Report for BCA Compliance

PROJECT NAME: Sydney Opera House – Renewal Project – Front of House – DA2a Submission  
Ballet Rehearsal Room & Function Centre

DATE: 21 September 2016

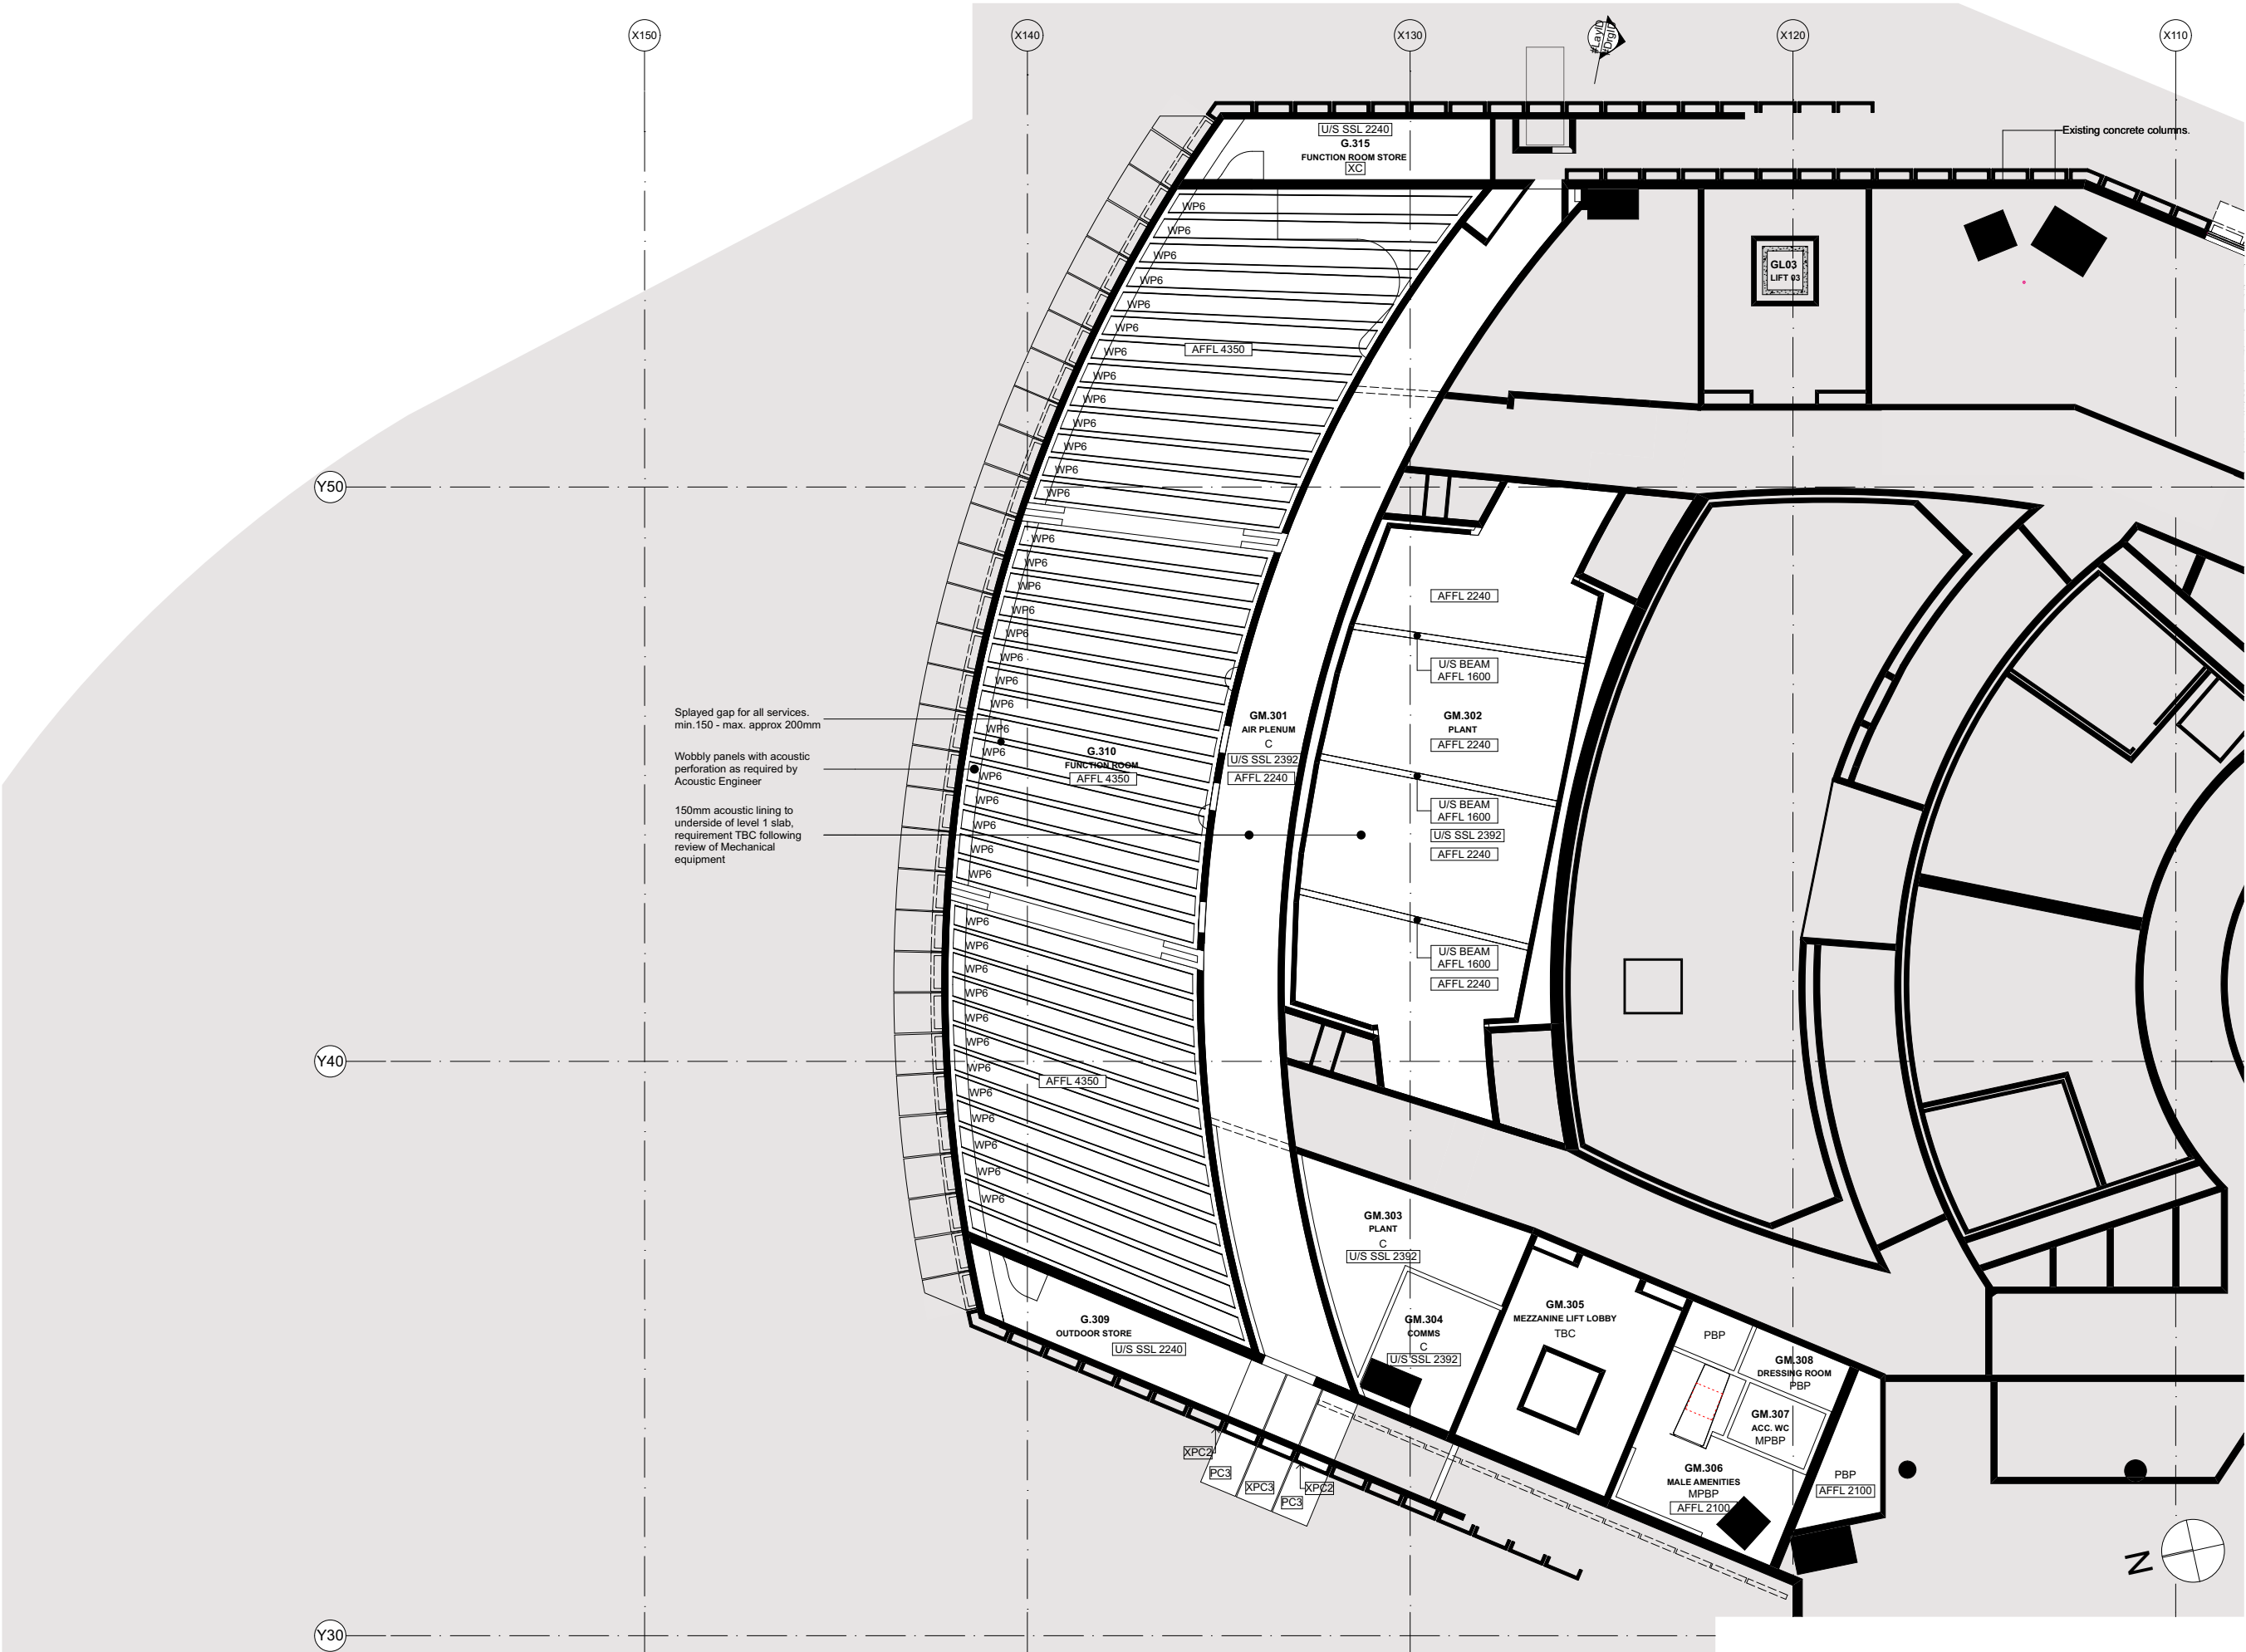
9	Closed Out.	-	-	-
10	Closed Out.	-	-	-
11	Closed Out.	-	-	-
12	Removed – N/A to DA2A	-	-	-
13	Closed Out.	-	-	-
14	The Corridor G.311and Foyer G.302 of the FC contain localised ceiling heights of less than 2700 mm, actual 2400 mm.	This non-compliance is required to be addressed via a Performance Solution from an Ergonomics Consultant.	F3.1	FP3.1

LIFT 08 REQUIRED FOR ACCESSIBLE GUEST ACCESS TO FUNCTION CENTRE AND ACCESSIBLE ACCESS TO PROPOSED FUNCTION CENTRE DRESSING ROOM LOCATED ON MEZZANINE FLOOR IN EXISTING STORE ROOM GM500/1, DIRECTLY ABOVE PROPOSED NEW FUNCTION CENTRE AMENITIES.

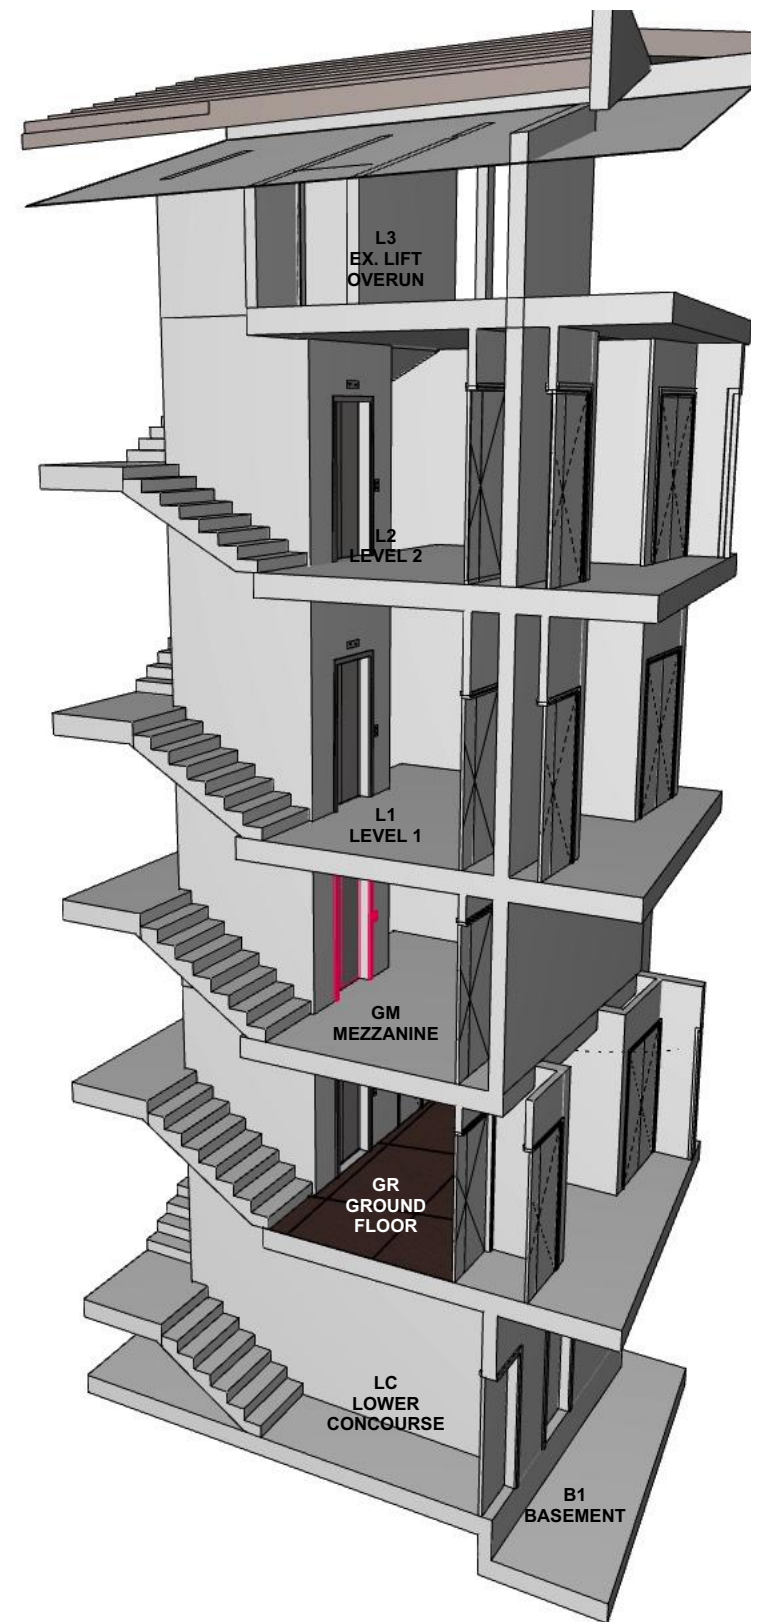
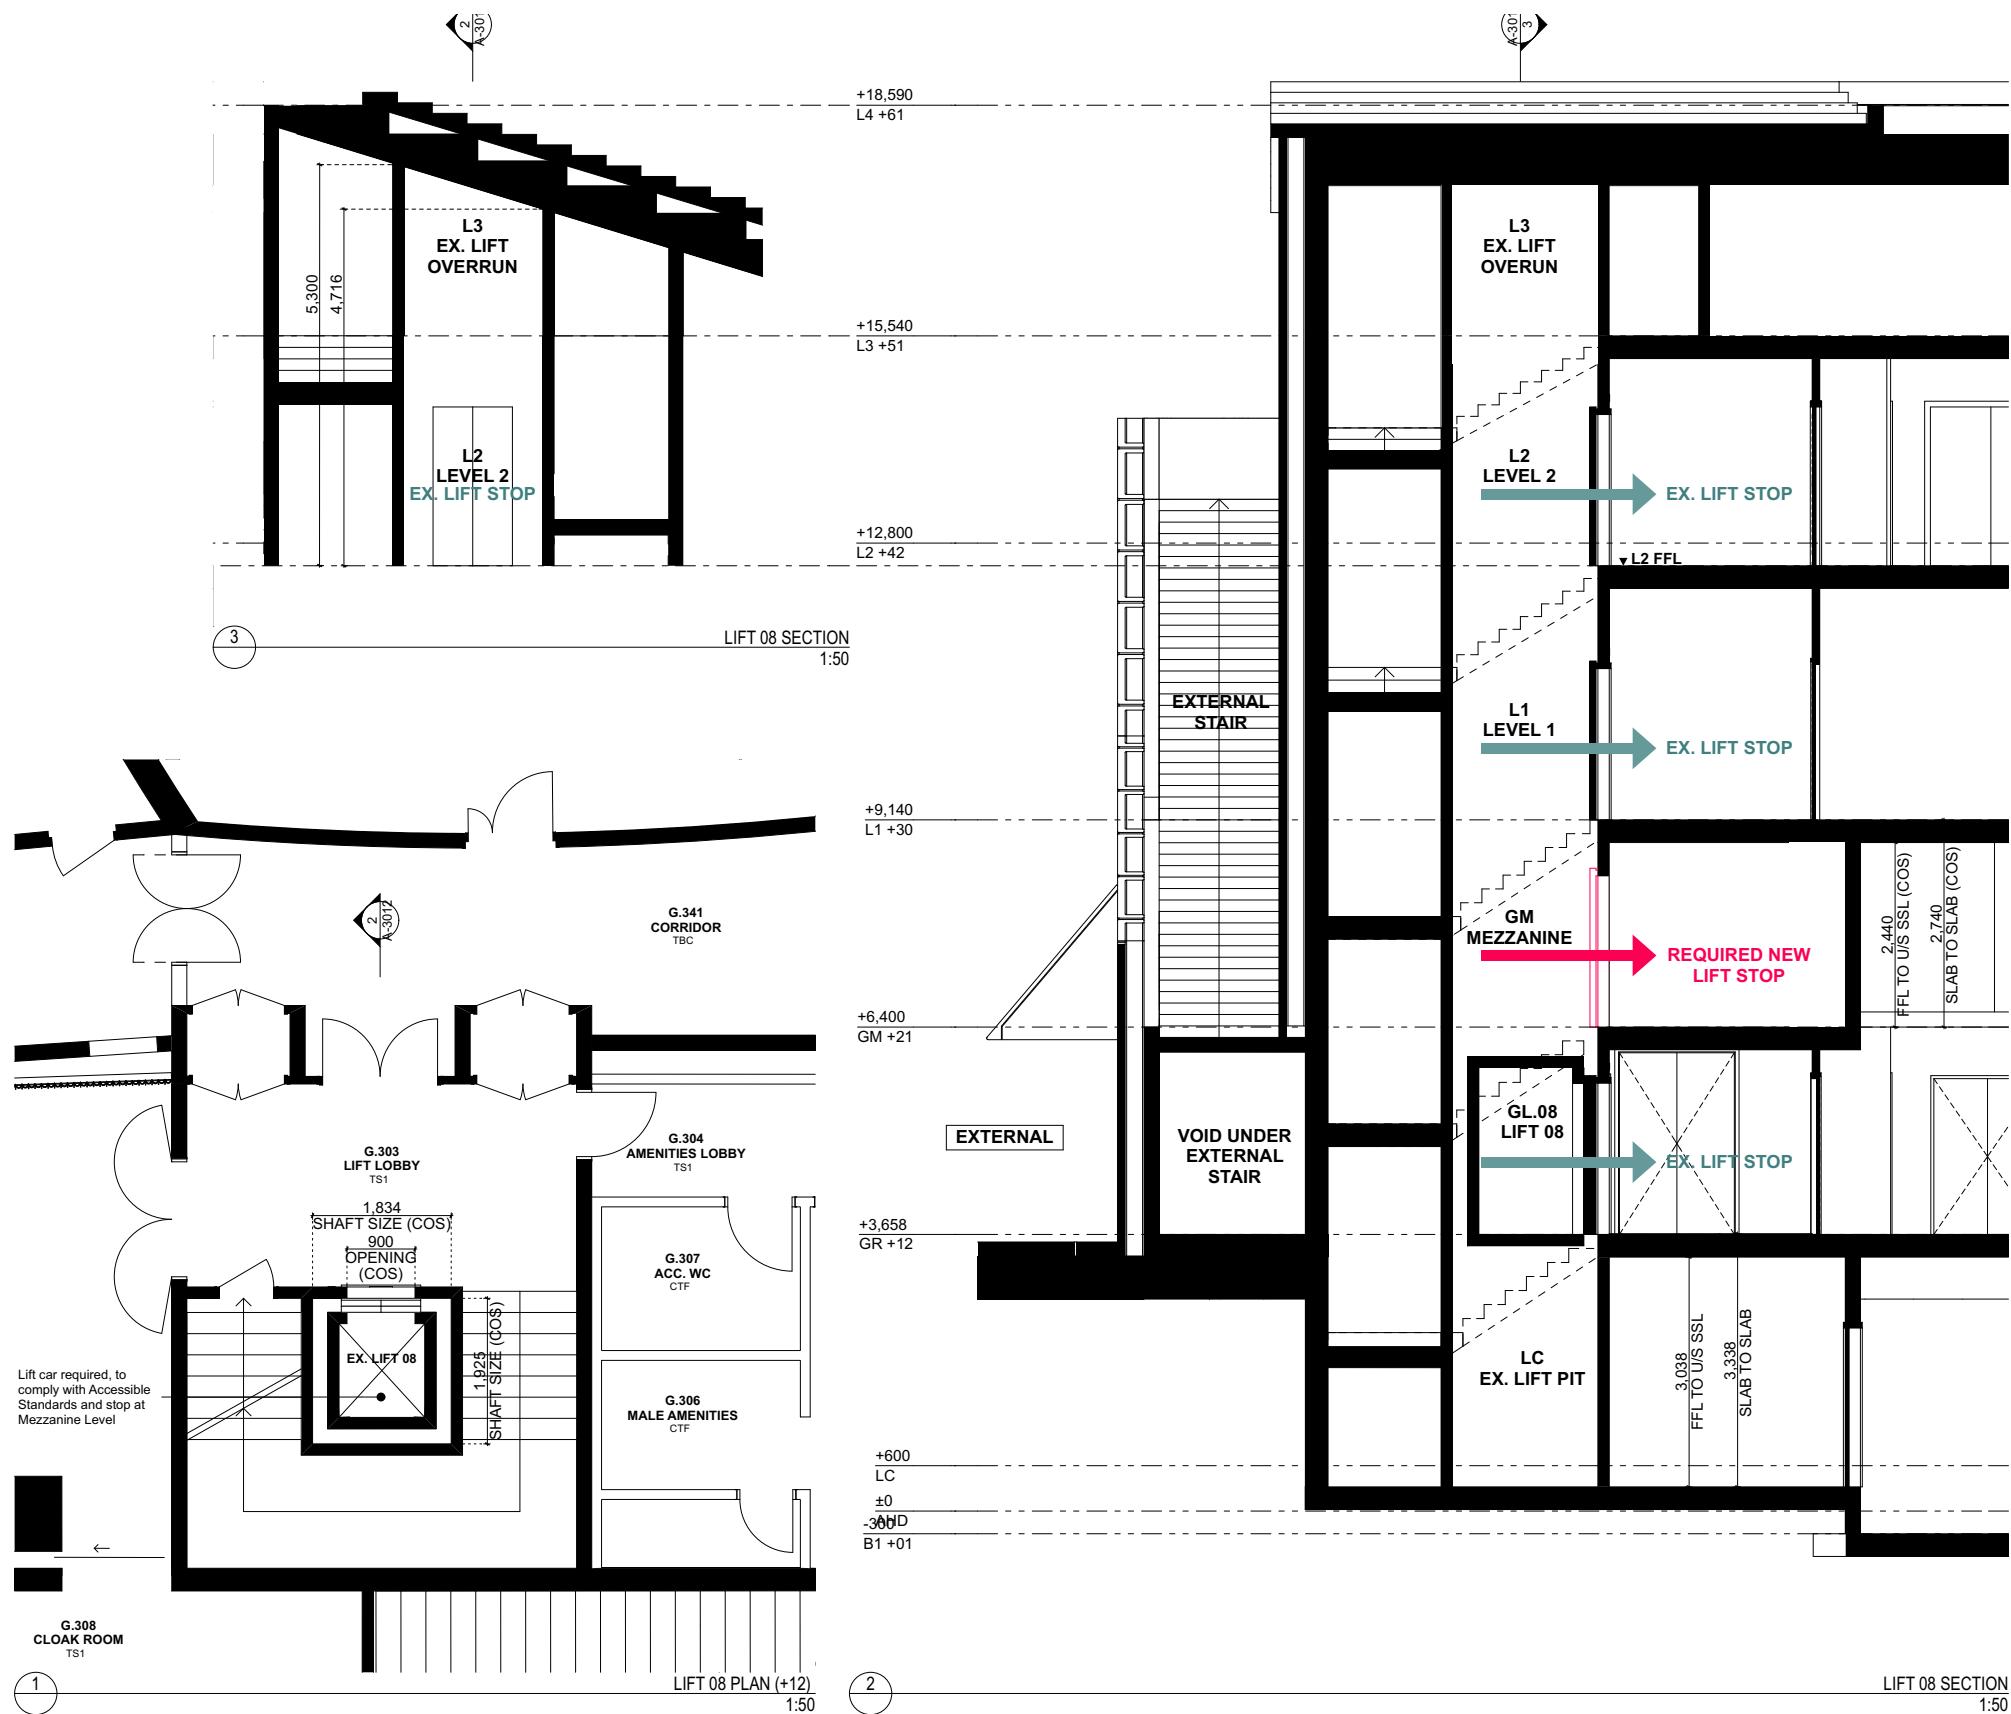
Item No.	Query or DTS Non- Compliance	Suggested Resolution	BCA Clause	BCA Performance Requirements
1	<p>FC – Proposed alterations to Mezzanine Level Stair 2 / Lift 8 are to the extent that cause a requirement for an upgrade consideration to be given to Stair 2 and Lift 8, for compliance with BCA 2016, see Figure 2.</p> <p>The DA2 BCA Report dated 5 August also requires this stair and lift to be considered for upgrading along with Stair 26 &amp; Lift 3 for the Eastern Accommodation Project documentation.</p>	Fire Safety Engineer to review and confirm the feasibility of Performance Solutions. Refer Table 6 below for specific non-compliances.	Refer Table 6 below for specific non-compliances.	Refer Table 6 below for specific performance requirements.
2	Removed – N/A to DA2A	-	-	-
3	Removed – N/A to DA2A	-	-	-
4	Inadequate fire hose reel coverage. Areas cut off by the fire compartmentation Design.	<ol style="list-style-type: none"> <li>Proposed fire compartmentation plans to be completed.</li> <li>Fire Services Engineer to review and nominate shortfalls.</li> <li>Fire Safety Engineer to then comment on the feasibility of justification via Performance Solutions.</li> </ol>	E1.4	EP1.1
